ISSUE SPECIFIC HEARING 1 – 7TH May 2026 – BOROUGH COUNCIL OF KINGS LYNN AND WEST NORFOLK – DEADLINE 1

## 2.9 Statutory Historic Environmental Features Plan

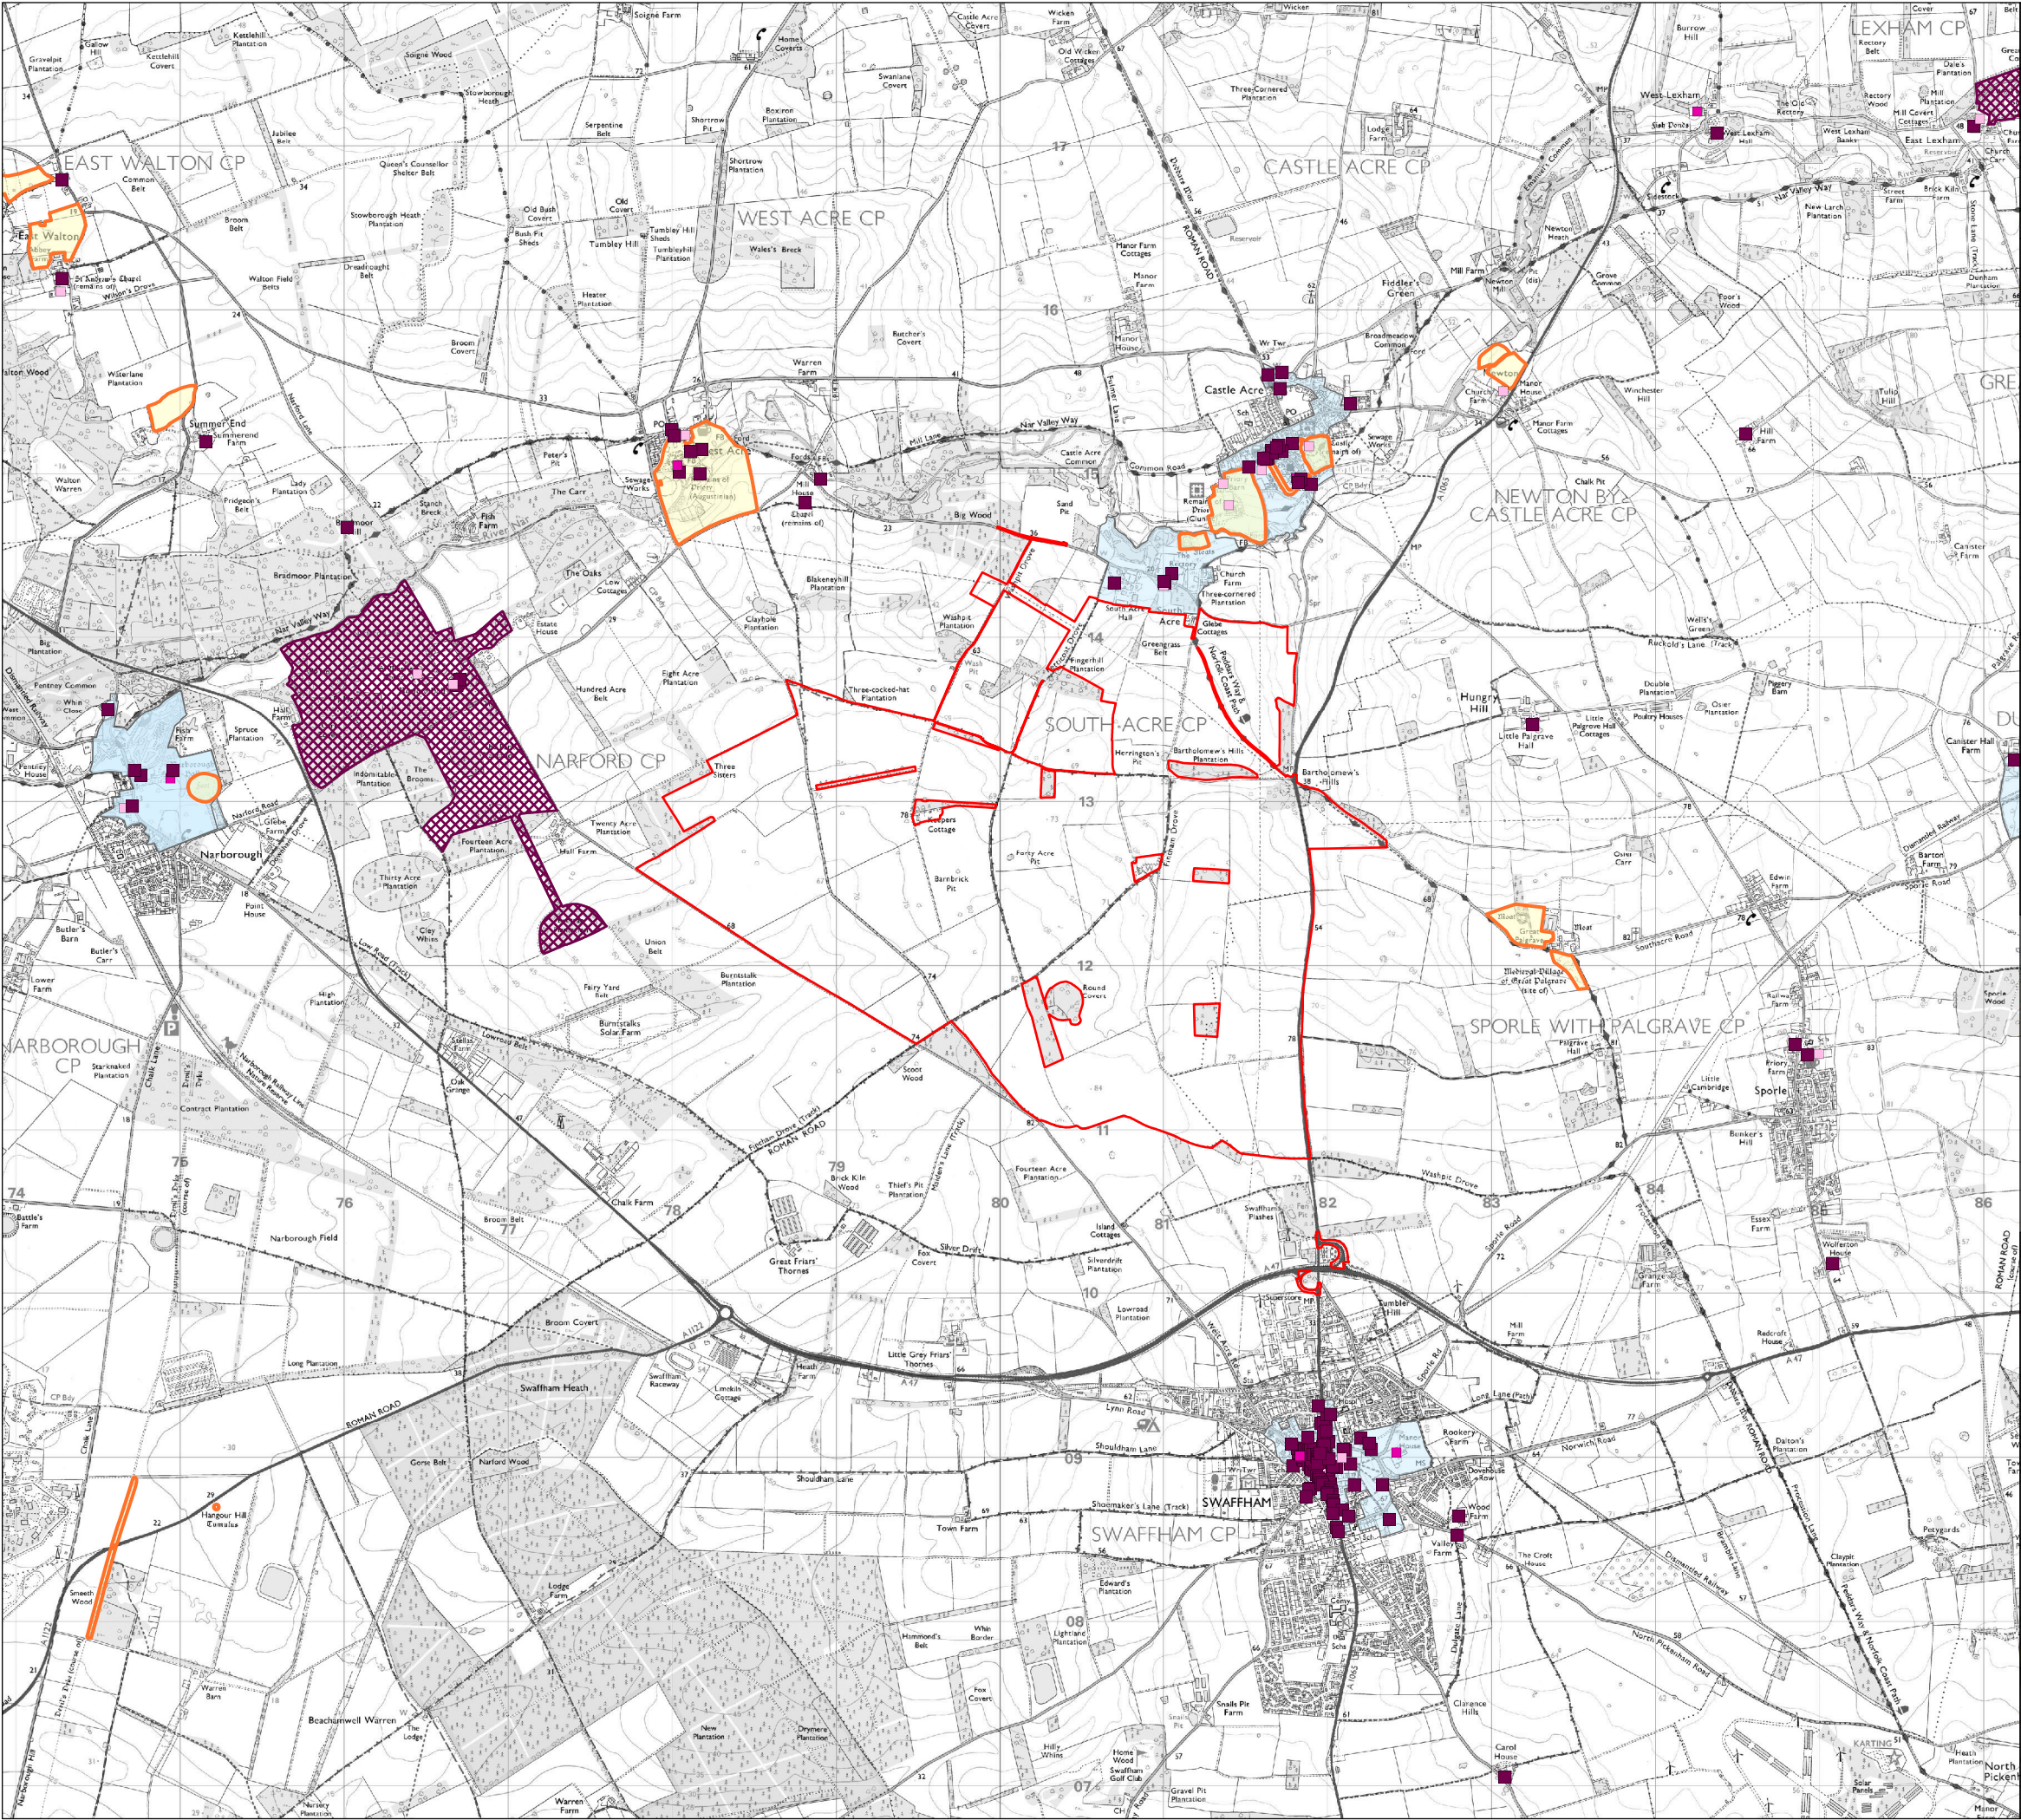
<p>Cultural heritage</p>		
<p>3.6 ExA comments in relation to Castle Acre. Assessment of castle</p>	<p>The main matter of concern is the fundamental understanding of why these buildings are <i>where</i> they are and <i>are</i> what they are. Castles were built to dominate their surrounding landscape and</p>	<p>APP-055 APP-057</p>

<p>and priory underplayed. Significance of CA undervalued. Further consideration needed. No explicit reference to level of harm, required for weighting of harm versus benefits.</p> <p>1) adequacy of assessment of setting of assets 2) explain how significance of CA has been considered 3) explain assessment of level of harm</p>	<p>Castle Acre does this particularly well. The valley setting is also rare for Norfolk, visible from a distance - e.g A1065, as is the land's relationship with the church and priory. The scheme impacts upon a Scheduled Monument and Grade 1 buildings of the highest significance.</p> <p>Ultimately the purpose of a castle is that it is visible to/from wider areas and provides views towards wide distance. The view back towards the castle and landscape is just as important as the view from the castle grounds outwards.</p> <p>It is hard to link heritage considerations discussed in the heritage submission with the content of the LVIA,. Given the considerations at hand these documents ought to be better linked. The castle was always intended to be visible and is supposed to have views. Its dominance in the landscape is key and the Council would argue its setting is intrinsic to significance as the Castle was constructed there for a reason.</p> <p>In terms of the Conservation Area, this is a collection of highly grade assets and non-designated assets (see Castle Acre Conservation Area Appraisal). The Conservation Area is visible and recognisable from the A1065 as a grouping of buildings and built to be visible from distances away. The pantile roofs for example are highly visible on approach. The solar panels and associated paraphernalia would all be highly visible in this same viewpoint.</p> <p>Whilst the Council agree with less than substantial to Castle Acre Castle, it is not a low level of less substantial. The level of harm should be considered as at least moderate as a result of the intrinsic significance. The significance is not just aesthetic and the Council agree with Historic England in this regard.</p> <p>The clearly perceptible change in character from one of agriculture to semi industrialised would be harmful to appreciation of the castle's command over the landscape as a whole. As you breach the ridge adjacent to Barts Hill, appreciation of Castle Acre as a village - conservation area impact is moderate, castle setting is moderate. Built to command over the landscape views. Stick to moderate.</p>	<p>AS-060</p>
